Proposed 2-storey front extension.
3 Meadow Way Littlehampton

Thank you for your internet representation made on 27th January 2020 which has been recorded as '**an objection**' with the comments as follows:

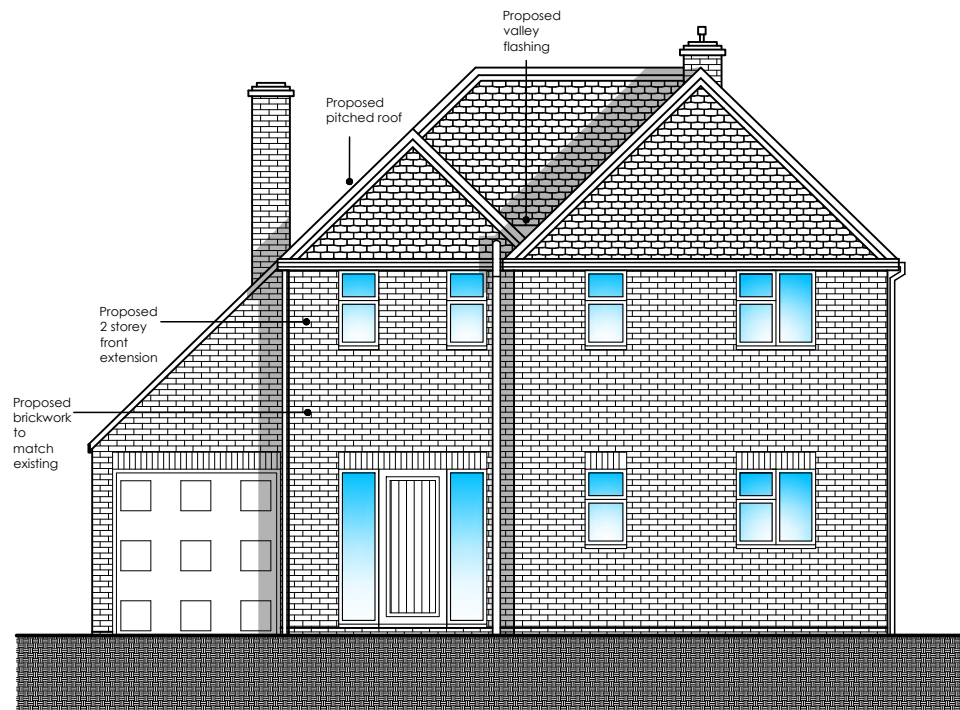
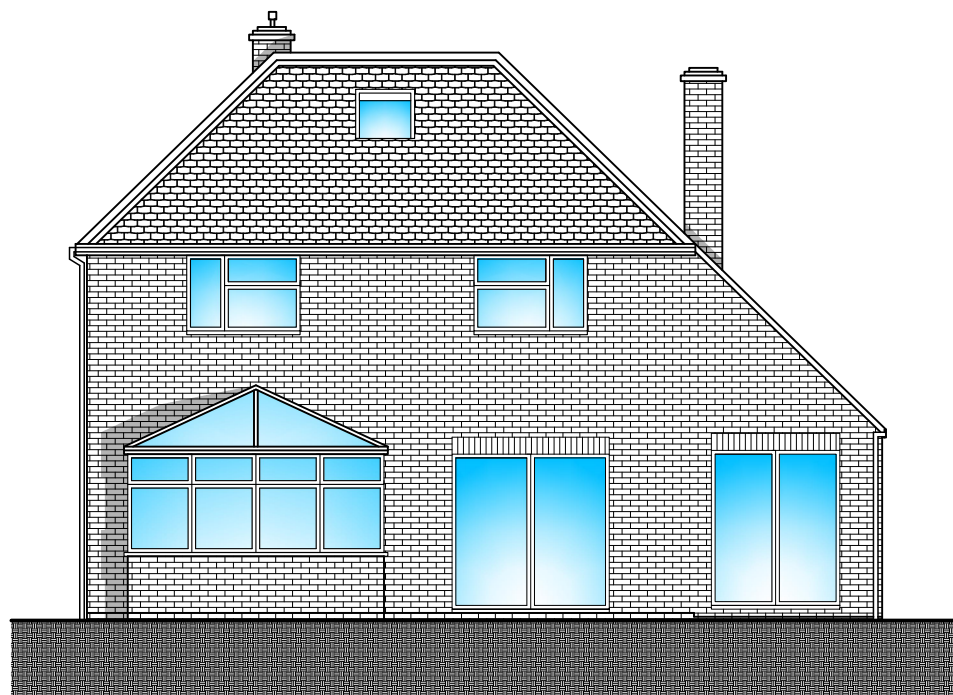
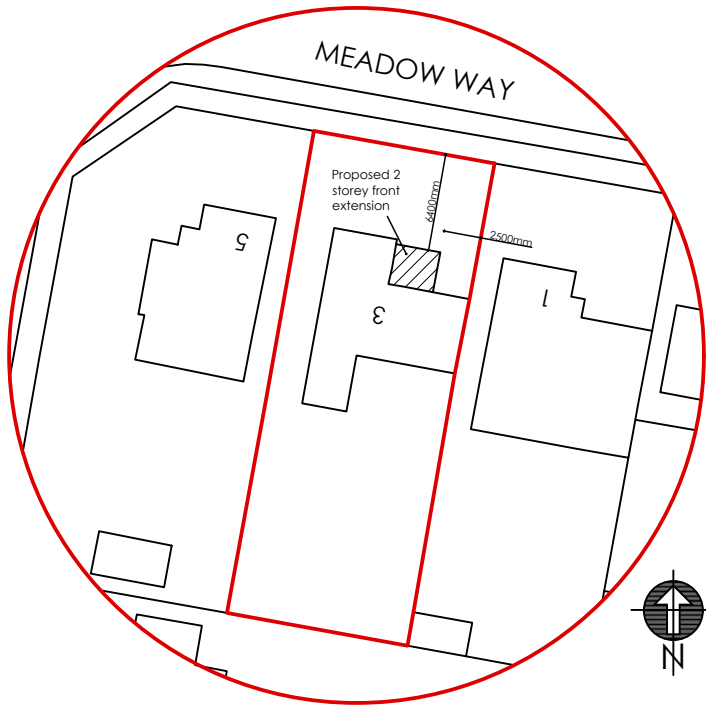
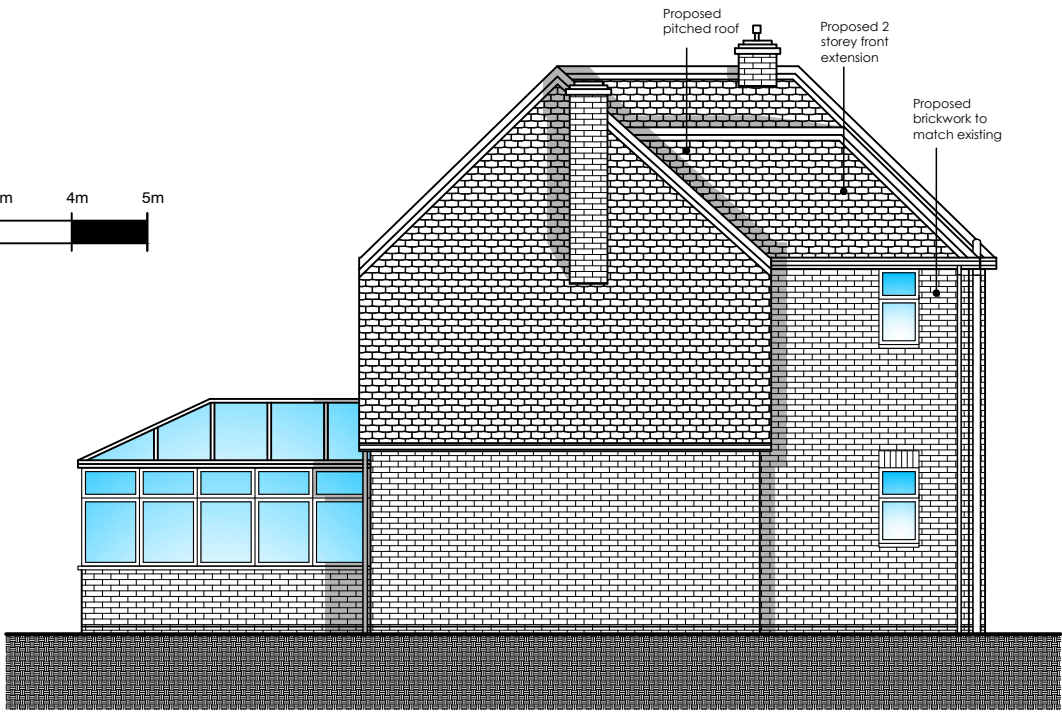
WINDOWS ON SIDE OF FRONT ELEVATION LOOK DIRECTLY DOWN INTO MY KITCHEN CHANGE WINDOW TO FRONT ELEVATION OR AT WORST MAKE THEM NONE OPENING OBSURED GLASS WAS TOLD IT WAS A PORCH NOT TWO STORY EXTENSION THE POSITIONING OF THE SECOND STORY WINDOW FACING MY PROPERTY WILL AFFECT THE PRIVACY OF MY HOME
